From: [Elizabeth](#)
To: [Rachael Stevie \(CD\)](#); [CDS User](#)
Cc: [Elizabeth](#)
Subject: Public Comment for LP-21-0001
Date: Wednesday, April 21, 2021 3:20:39 PM

My name is Liz Ritzenthaler. Our family lives at 904 Bull Rd. I have read through the online documents about the proposed Bull Ranch Long Plat. I would like to make the following remarks:

STEVE LATHROP
THE BULL RANCH
 PRELIMINARY SITE PLAN

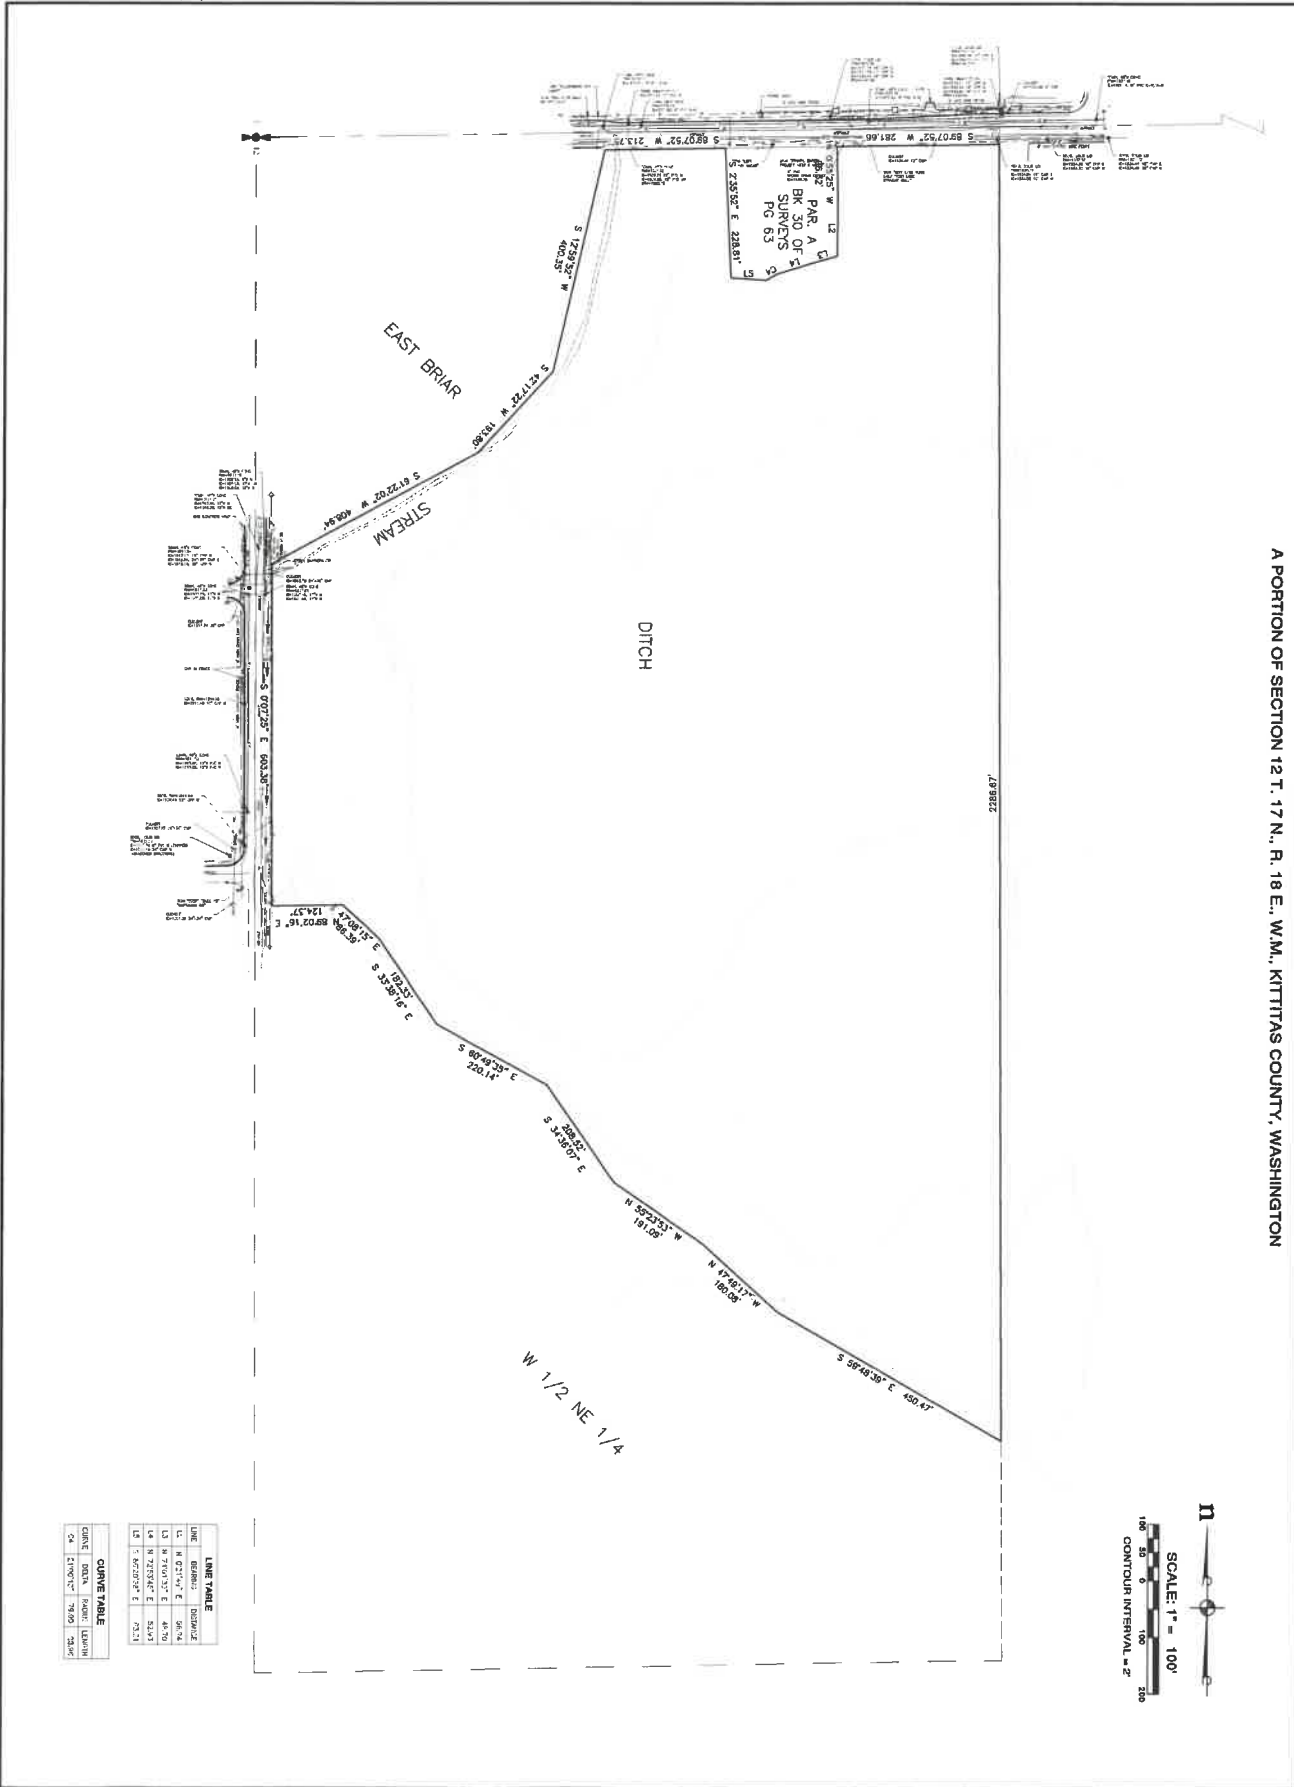
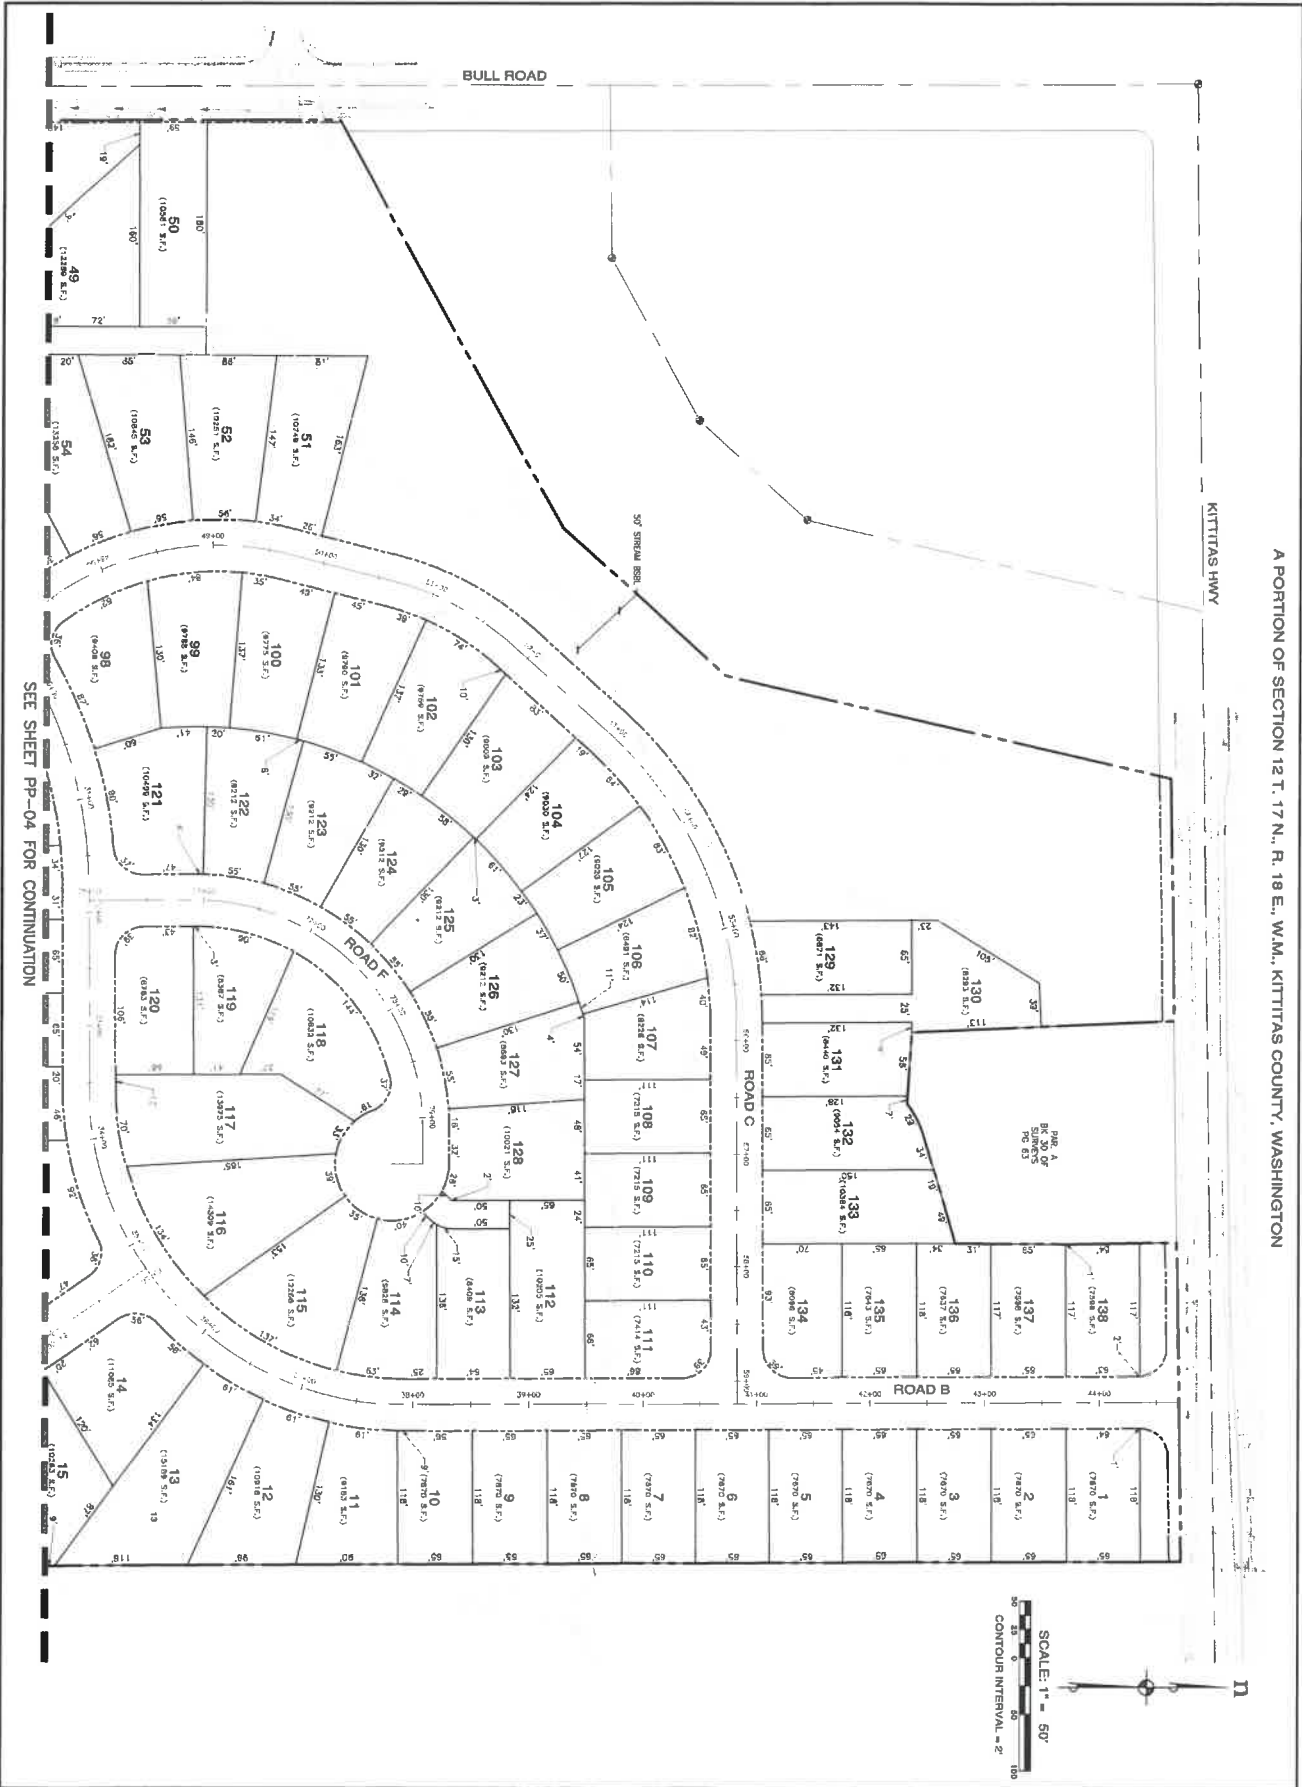
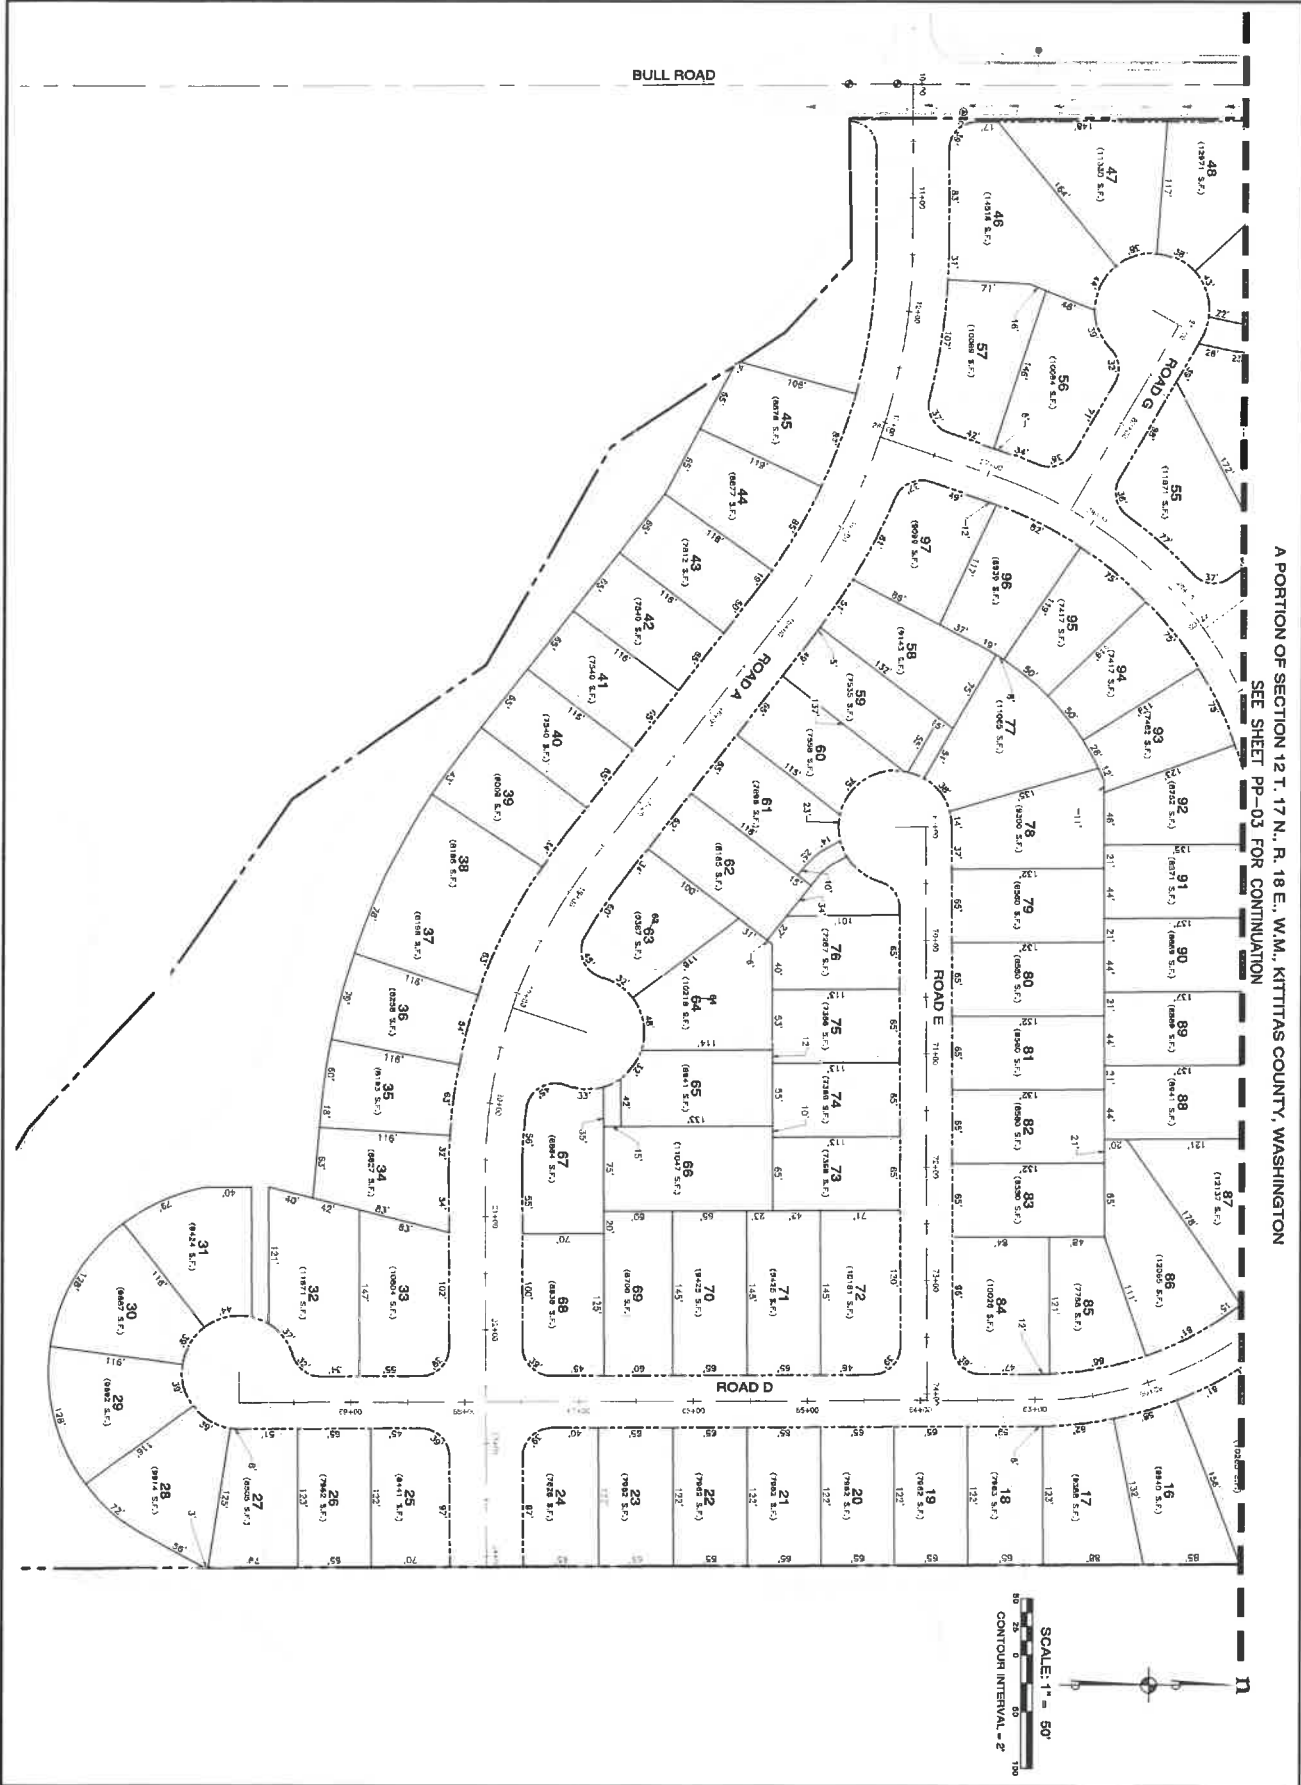
2) re sensitive areas: I am happy that the creek along the northwest portion of the project has been called out for 50 ft buffers, but I would hope they could be adjusted, if needed, to protect the special riparian tree that was highlighted in comments (and a calendar) by R. Arango in her public comments. The geoengineering report highlighted a steep slope setback that would impact a new access road and possibly lots 103, 104, and 105. I think this area they called out is close to the zone with the tree. Maybe refiguring this region of the development could be done during those early planning stages. A community-oriented open space with possibly a small playground comes to mind and might be less impactful and allow the access road to be shifted eastward into the region of lots 103, 104, and 105.
